**Written Representation Regarding ISH 13 – Landscape, Visual Impact & Design**

**On behalf of Marlesford Parish Council**

**Regarding NNB Generation Company (SZC) Limited DCO Application**

**24<sup>th</sup> September 2021**

**DRAWING TITLE:**  
 SOUTHERN PARK AND RIDE PROPOSED GENERAL ARRANGEMENT

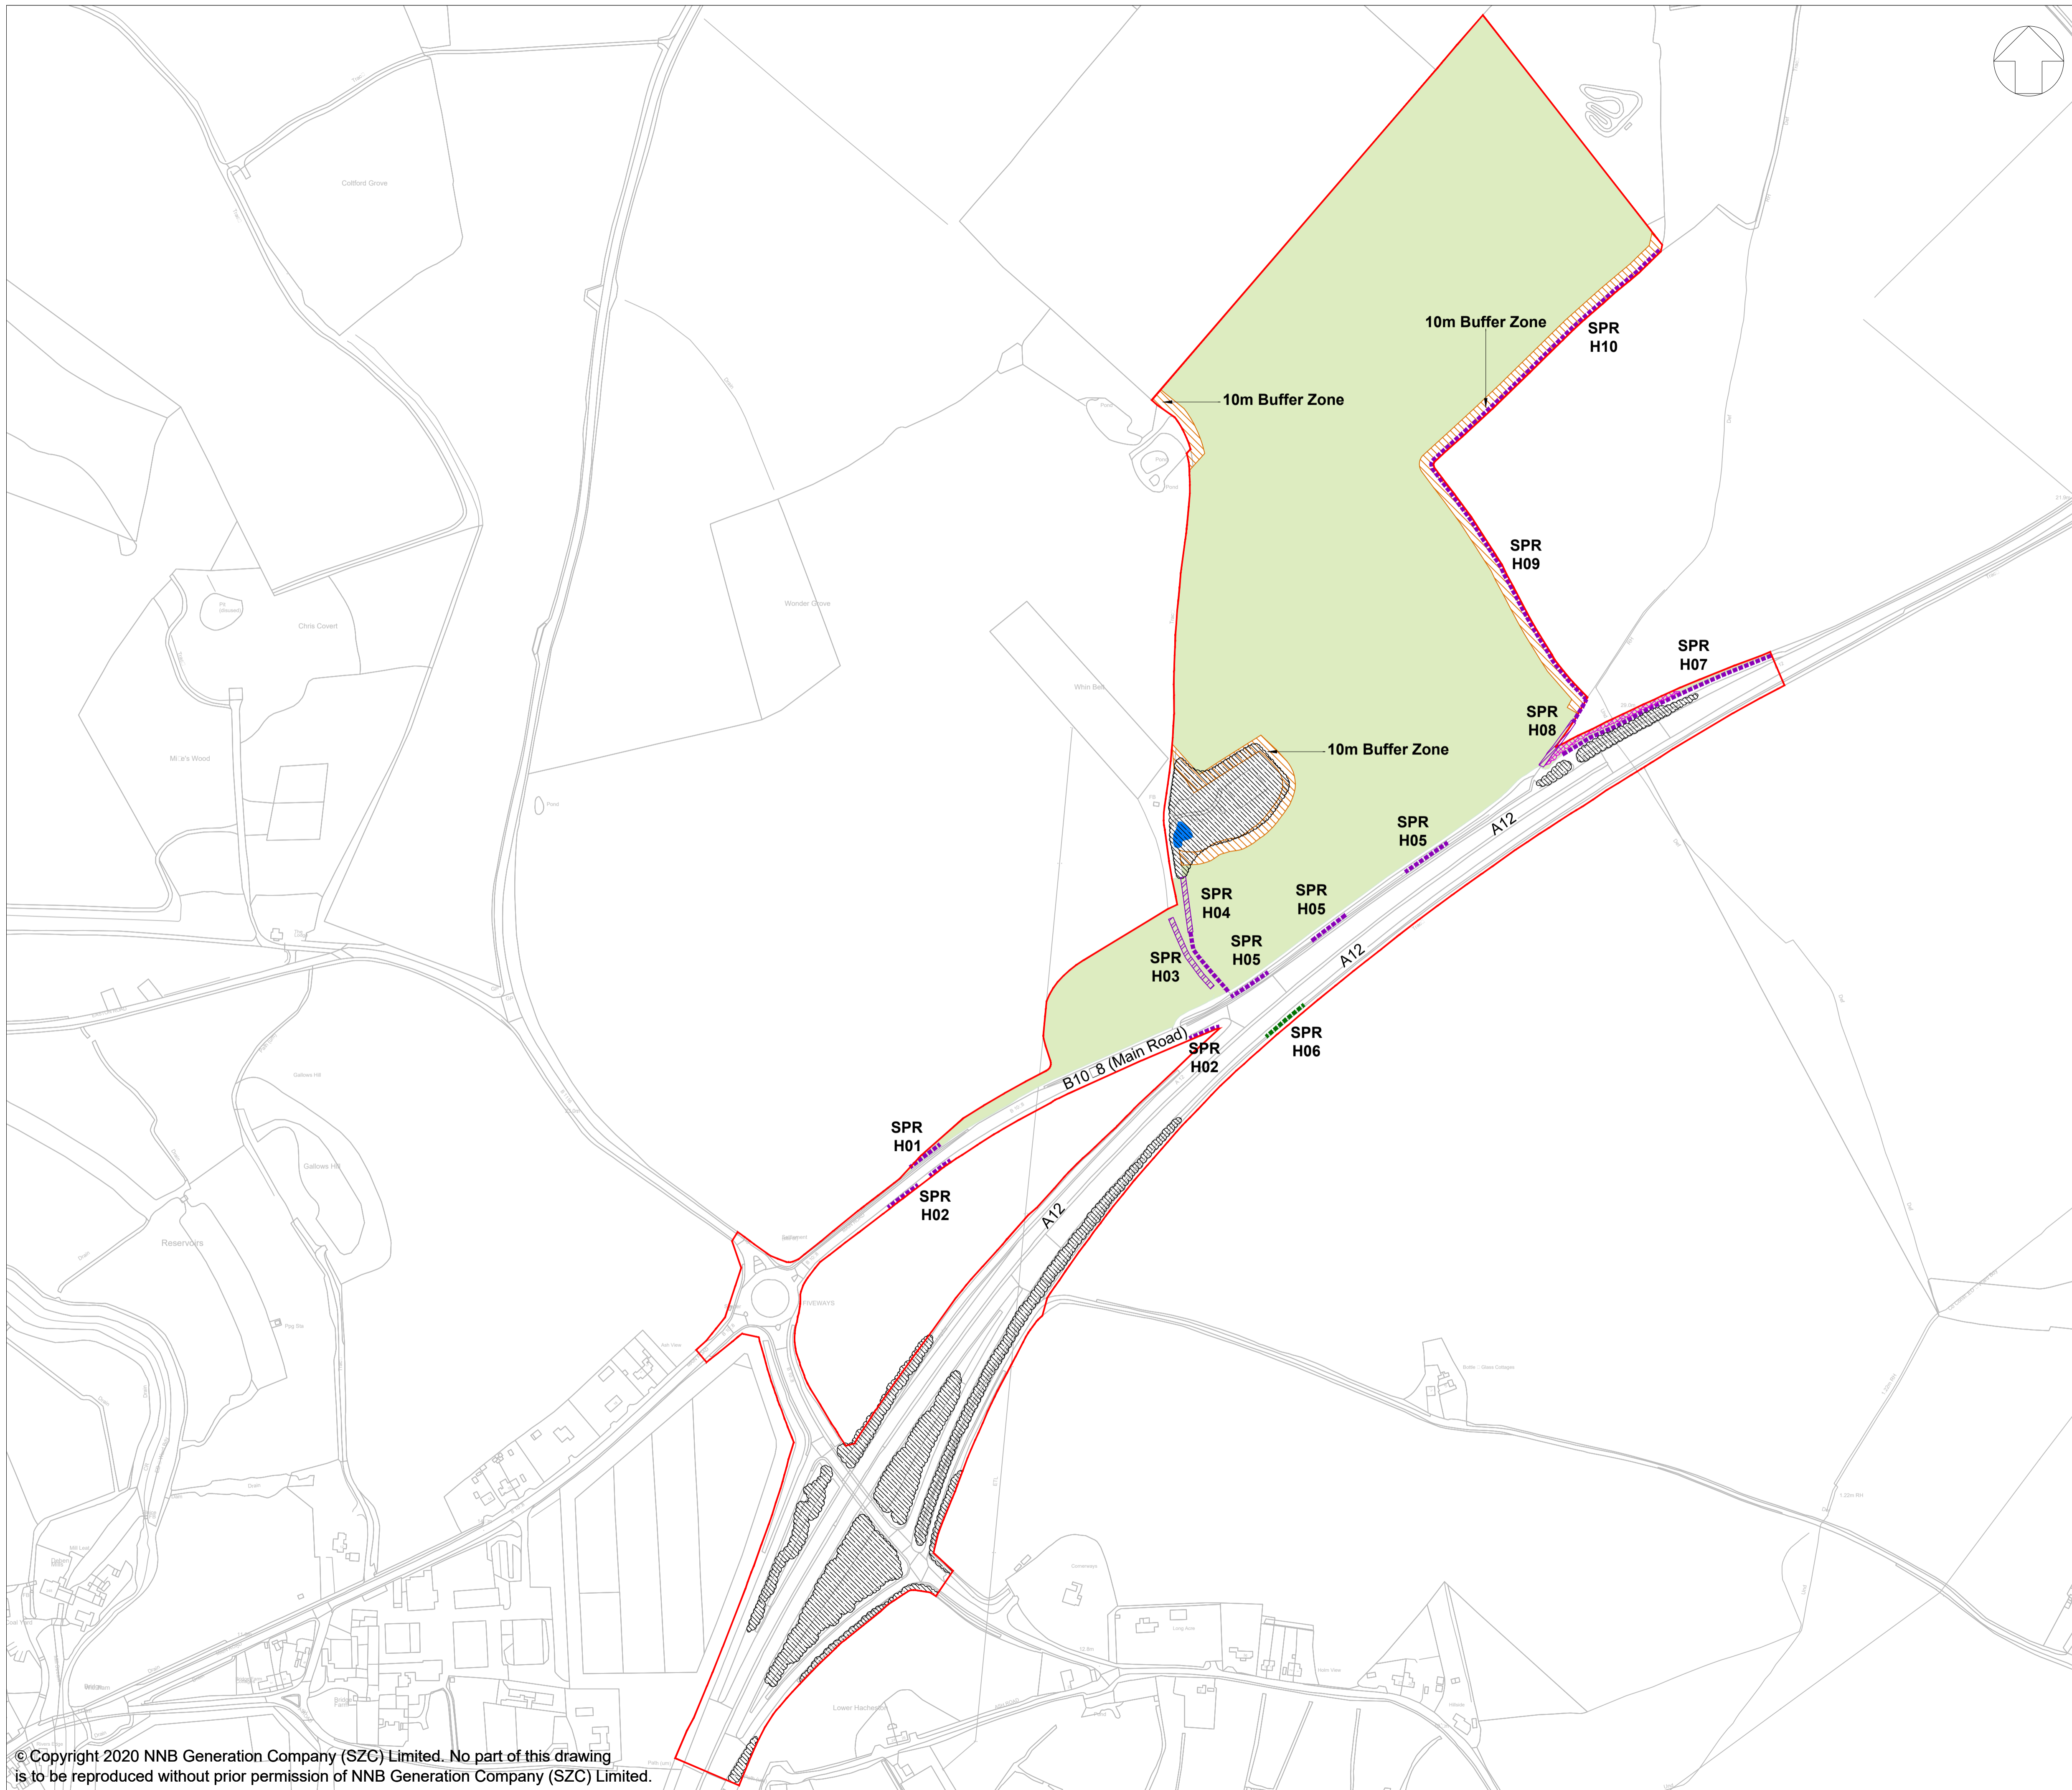
4.	<b>The need for high quality landscaping</b>	<p>i. The SP&amp;R site is on high ground, in a prominent position between the valleys of the Rivers Ore and Deben. It is therefore important that the site (if it is developed) is effectively and sympathetically landscaped to ensure that it is screened, and that new planting can be left as a legacy benefit after the SP&amp;R’s restoration to agricultural use.</p> <p>ii. We re-state that we have not had a substantive discussion with the Applicant on SP&amp;R issues since our meeting of 8<sup>th</sup> October 2020, but we acknowledge that at that meeting the Applicant indicated that they would be reinstating the northwest bund to its full length and this was included in the January 2021 DCO changes. We also recognise the retention of the ancient double hedgerow to the west of the site, although we await further detail on exactly how the access to the SP&amp;R will pass through it. However, we are not content with the proposed provision for screening the bridleway (immediately to the west of the site), from the site itself. At ISH 13 the Applicant stated that they had provided additional space in the site to allow for perimeter hedge planting adjoining the public right-of-way on the western boundary. From the plans, this would appear to be correct, but the boundary of the site is so close to the bridleway that hedging is going to provide almost no screening at all for the majority of the operational life of the SP&amp;R. When measured from Drawing No. SZC-SZ0701-XX-000-DRW-100164 Rev 02, Jan 2021 at 1:2500, at the closest point there is no more than 5m separating the bridleway from the internal roadway. <b>We ask that the Applicant does more to mitigate the impact of the SP&amp;R site for users of the bridleway.</b></p>

|  |  | <p>iii. We have raised in our submissions our concerns over the predicted growth rates for the planting proposed by the Applicant and in our response to the ExA's Second Written Questions [REP7-208] we set out why we believe that the growth rates will not be achieved in this particularly dry part of the country. We already have a concern that hedgerow planting will not provide effective screening in the first 5-7 years of the site's operation and any compromised growth as a result of drought or non-establishment will further exacerbate the inadequacy of the screening being proposed.</p> <p>iv. As well as planting within the red-line area, we believe that substantial <u>off-site</u> planting is required. We would want to see high quality planting in the following areas:</p> <ul style="list-style-type: none"> <li>• On the eastern side of the B1116 at Hacheston in order to improve screening from that road and for the properties to the west of the B1116, particularly The Rookery.</li> <li>• From the Fiveways Roundabout to the entrance to the SP&amp;R and beyond to the slip-road to the A12 north-bound, there is, in parts, an existing hedge and we welcome the Applicant's indication that existing hedgerows will be retained, but the hedge is patchy and will not provide adequate screening. We ask that where no hedge currently exists, new planting is carried out and where there is a hedge, it is supplemented with additional planting including hedgerow trees.</li> <li>• We believe that the north-eastern boundary of the SP&amp;R (which forms part of the boundary of the Traffic Incident Management Area) is a field boundary. For landscape enhancement and screening, we believe that this boundary should be planted with hedging and hedgerow trees.</li> </ul> <p>v. The access road into the SP&amp;R passes through the double ancient hedgerow which flanks the bridleway. We had concerns about a veteran oak growing close to where the access road will enter the main part of the SP&amp;R site, but we welcome the assurances from the Applicant that this tree will be protected. The area around the entrance needs to be sympathetically landscaped to provide screening and the works to form the access road need to be far enough from the veteran oak to avoid damage to its root system.</p> <p>vi. The Applicant has stated a number of times that it wants to leave legacy benefits that remain after the operational life of the SP&amp;R. We agree with that and would urge the Applicant to contribute to its legacy by generous, appropriate and effective planting in and</p> |  |

around the SP&R and in particular, the use of hedgerow trees that in time will make a significant contribution to the wider landscape.	
5.	<b>The lighting of the SP&amp;R</b>	<p>i. We note the response of the Applicant to the ExA Second Written Question LI2.34 [REP7-053] which relates to MPC’s request for the Applicant to consider low level lighting. We can understand that the Applicant needs to achieve appropriate lighting levels across the operationally active parts of the site and we can appreciate that there are practical constraints that potentially limit the use of lower height lighting columns. We understand that the Applicant is doing what it can to limit light spill from the site ie light cast onto the ground ,and we welcome the Applicant’s commitment to using light fittings that limit light spill and use LED-based fittings with zero-degree tilt and demountable shields, but we also have concerns about skyglow and visible light from the site which we believe will be seen over a wide area and certainly from the villages of Wickham Market, Hacheston, Marlesford and Campsea Ashe. <b>We ask the Applicant to use its best endeavours to limit skyglow and visible light from the SP&amp;R.</b></p> <p>ii. We draw the ExA’s attention to a statement in Para 1.4.13 of Book 6, Vol. 4, Chapter 6, Appendix 6B where the Applicant states <i>“The proposed development would introduce a large area of lighting within the LCT, in an area where there is a small area of existing lighting of a similar type and intensity but at some distance from the site. This would result in long-term effects on this LCT that would be medium scale and occur over a localised extent. Effects would be of medium magnitude, resulting in a moderate adverse effect, which is considered to be not significant, given the relative lack of existing artificial lighting in the vicinity of the site”</i>. This suggests that the Applicant recognises the development will have adverse impacts in the area from the lighting of the SP&amp;R, but it concludes that the impact is “not significant”. It then appears to confuse matters by acknowledging the <i>“relative lack of existing artificial lighting in the vicinity of the site”</i>. We contend that it is exactly this issue which will contribute to a greater impact than the Applicant is suggesting. <b>We are looking for clarification from the Applicant on this statement.</b></p> <p>iii. Tom Whipple, Science Editor of <i>The Times</i> on September 21st, 2021, commenting on a letter to <i>The Times</i> on the same day by Lord Rees of Ludlow (the Astronomer Royal) states that in the UK, an estimated 61 per cent of people live in areas with “severe light pollution”. Whilst here, we are not officially a “dark sky” area, night skies are nonetheless relatively free of light pollution and we do not want the area around the SP&amp;R to add to</p>
